Application by RWE Renewables UK Solar and Storage Limited for an Order Granting Development Consent for the Byers Gill Solar Project. PINS Reference No: EN010139.

The Examining Authority invited all Interested Parties to submit 'Comments on responses to ExQ1 by Deadline 3 by Thursday 19th September 2024 .

Bishopton Villages Action Group Comments on Applicant's Responses to ExA Q1

Scale at A1 1 : 1000 & 1 : 500

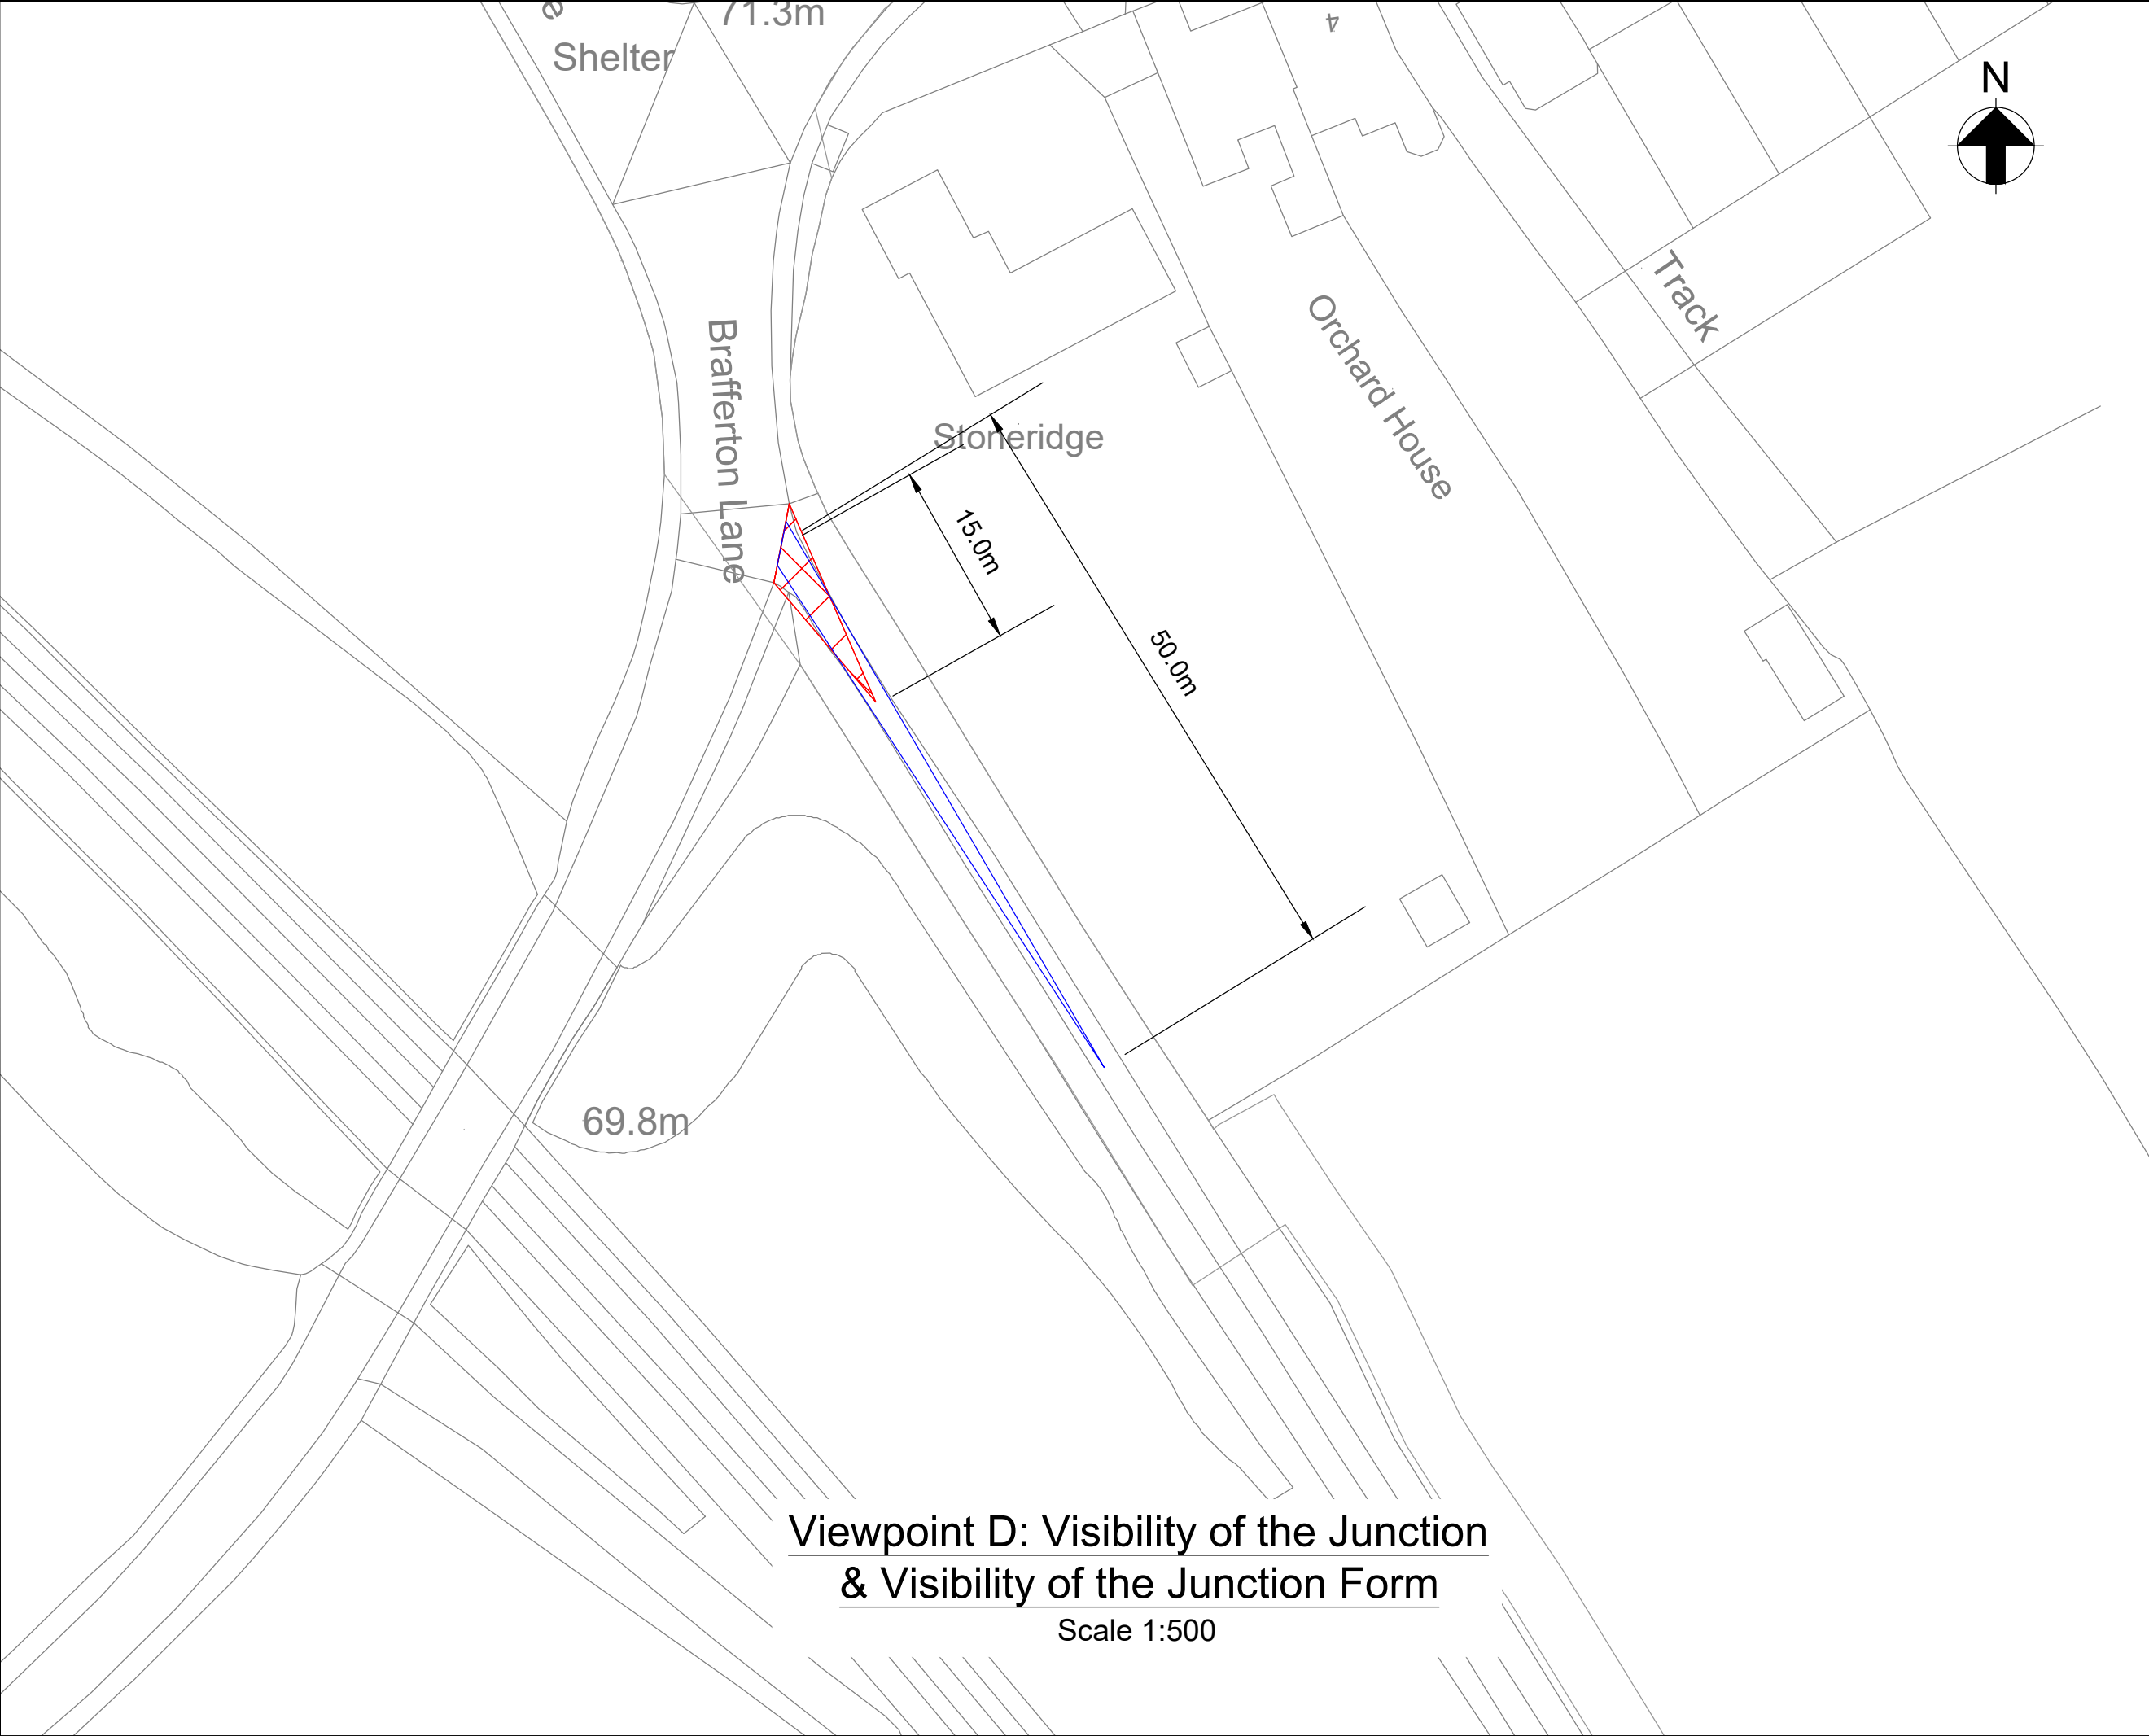
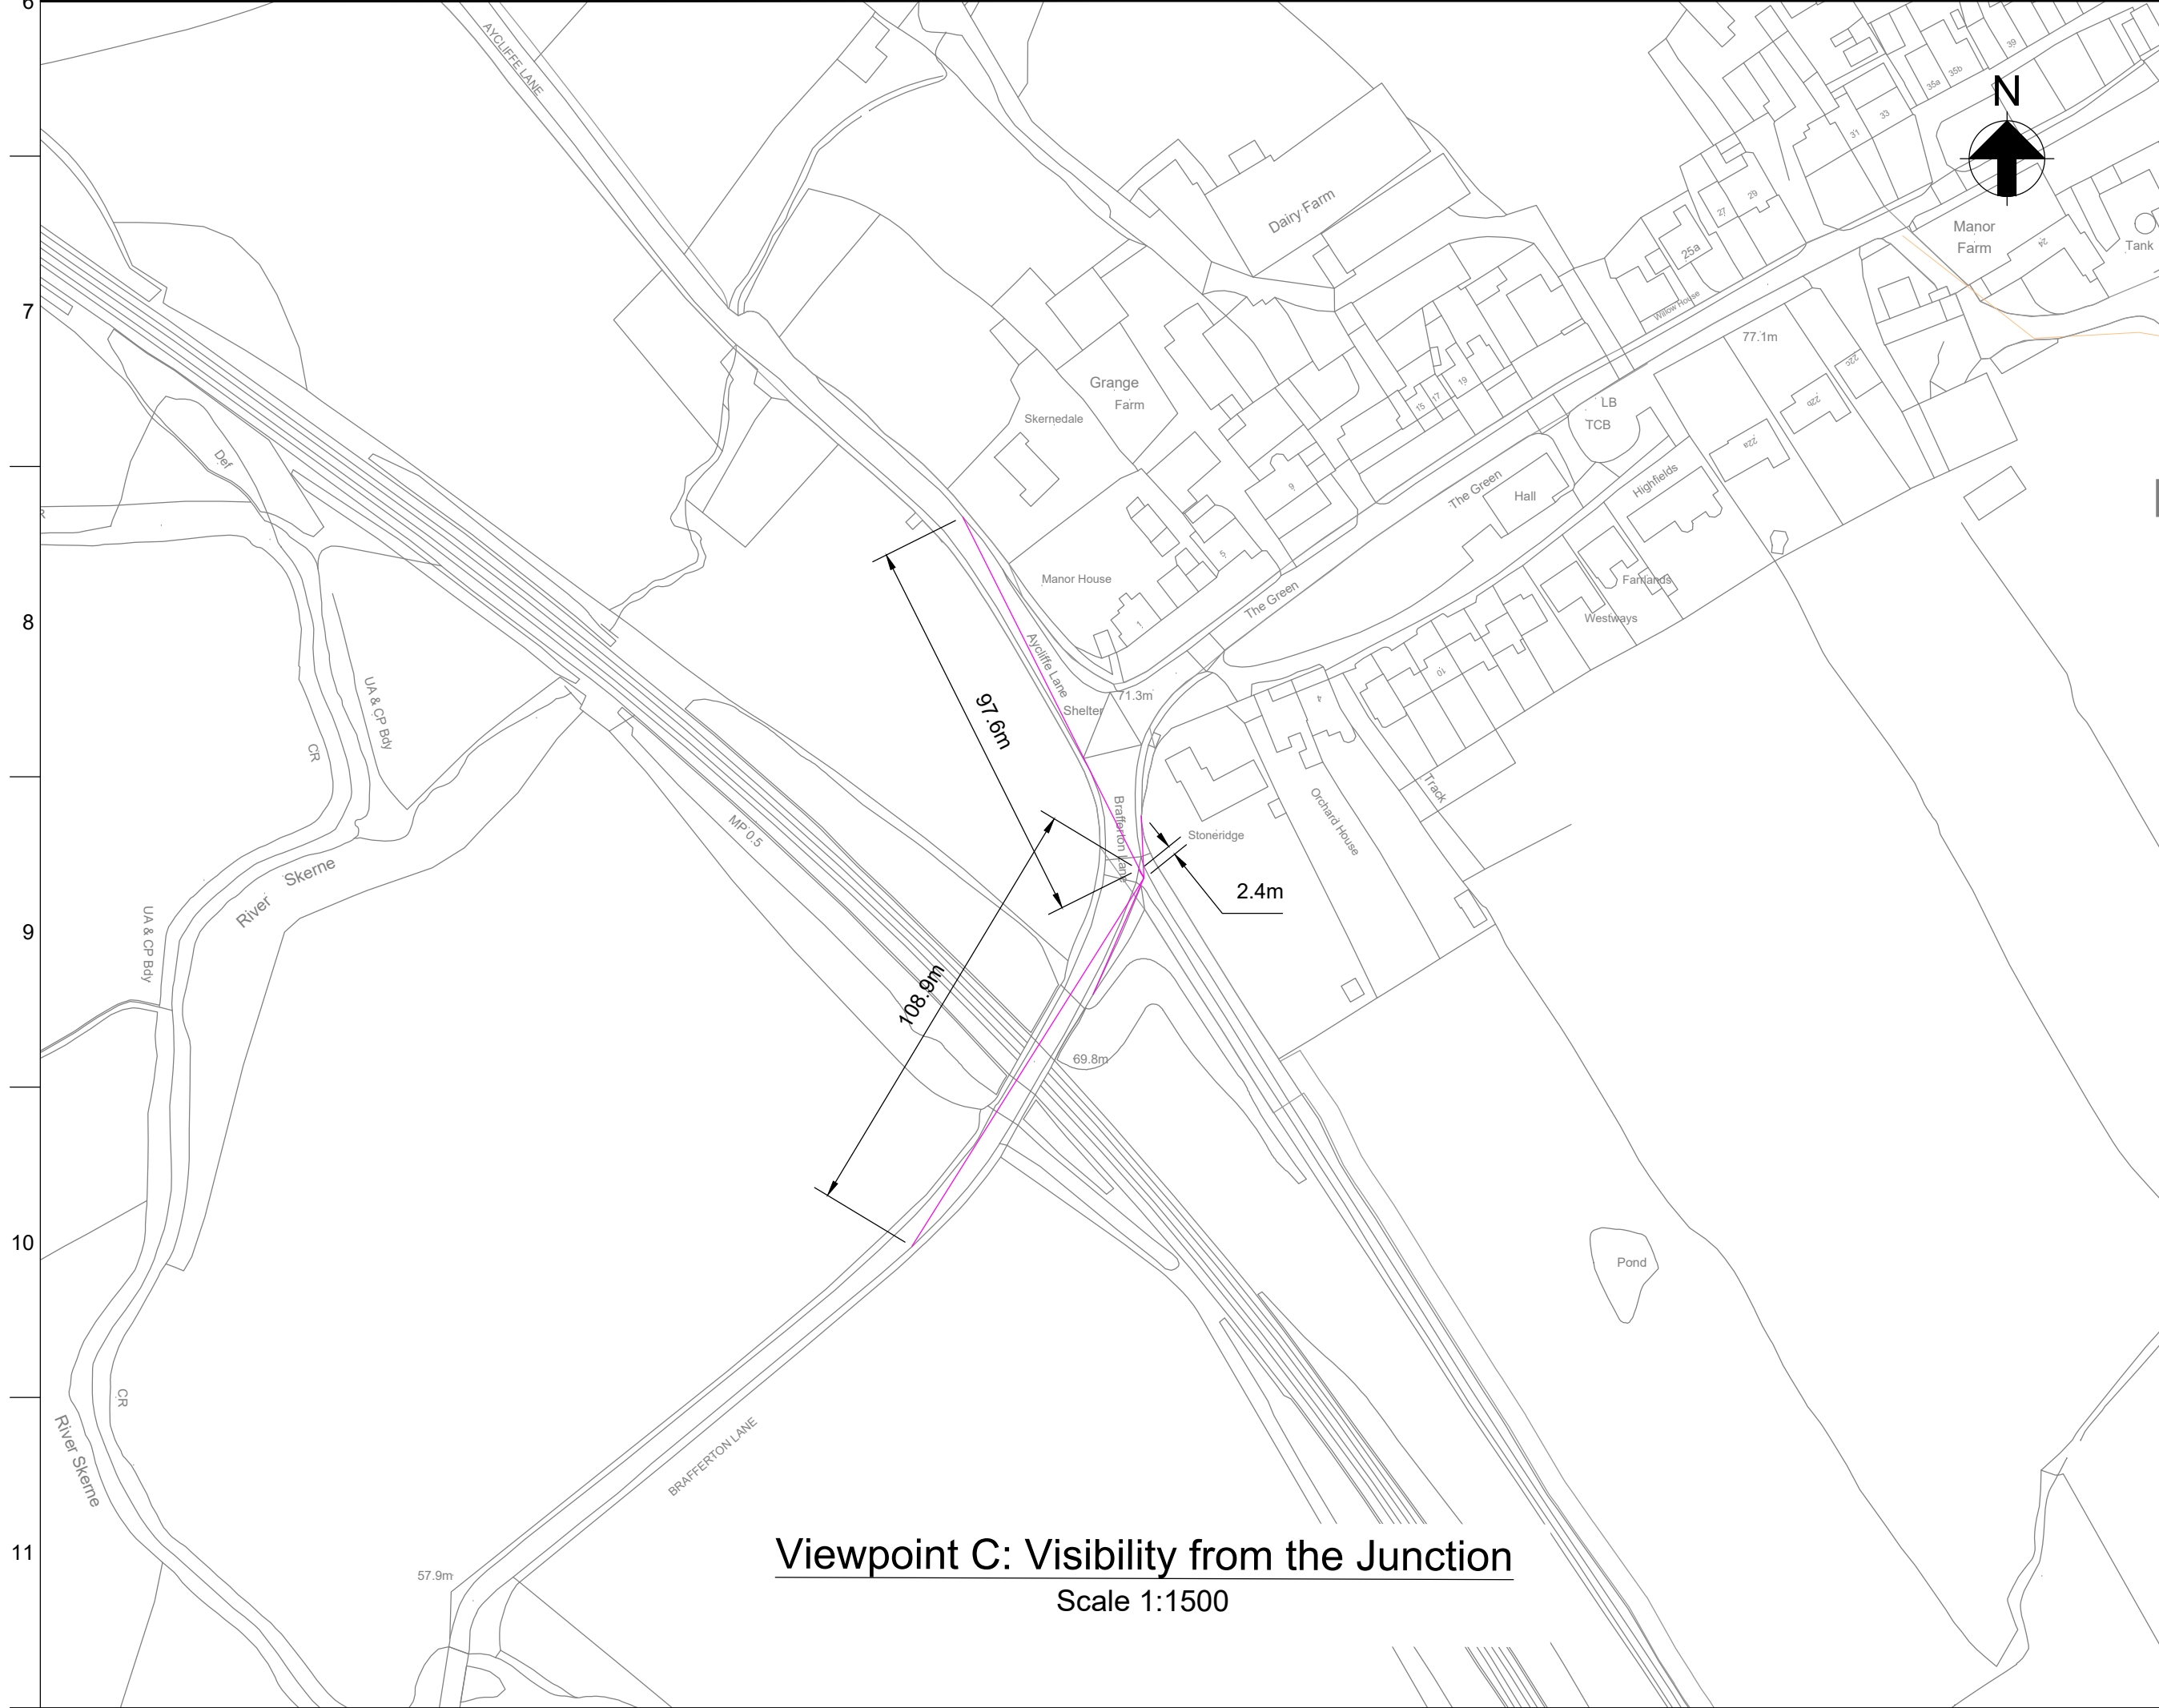
TT.1.23	Re existing access point to the southern section of Panel Area A	<i>The Outline CTMP [APP-112] highlight[s] that use of the access will need further consideration by</i>	BVAG is very concerned about the various significant adverse effects likely to arise from

<i>the Principal Contractor, when appointed, to ensure it can operate safely.</i>	<p>proposed access to the site, but specifically, access to Area A south and north.</p> <p>Insufficient survey, analysis and assessment has been carried out to establish whether access to Area A is feasible as proposed, or at least, without giving rise to extensive and permanent adverse effects on landscape, views, biodiversity as a minimum. See doc. REP2-044 paras. 4.2.2 - 37.</p> <p>These matters need to be addressed during the Examination, not when a contractor is appointed.</p>
TT.1.24	As above	As above	As above
TT.1.33	<p>Re Applicant's claim that <i>due to a negligible increase in traffic on the LRN, the impact on pedestrian, horse riding and cyclist amenity will not be material, and, if at all, only in isolated locations.</i></p>	<p>The Applicant concludes <i>that there is expected to be a low level of impact from construction traffic on the amenity of pedestrians, horse riders and cyclists, and that the effect is not significant.</i></p>	<p>BVAG is very concerned about the various significant adverse effects on these and other receptors likely to arise from construction traffic at several locations. See for example doc. REP2-044 paras. 4.2.2 - 37. , and regarding horses specifically, paras. 4.8.2 ii), and 6.64.</p> <p>BVAG are very concerned about the lack of a commitment by RWE and their contractors to repair the damage to public highways which will result from construction works and would be liable for funding for repairs to Darlington Borough Council (i.e. local taxpayers). No mention is made of a commitment to repair damage in the CTMP.</p> <p>N:B: The ExA are encouraged to drive by the Whitfield Solar project to see an example of the damaged caused to the public highway by solar construction traffic. It would need only 5-10 mins to cover the route from already suggested itinerary.</p>
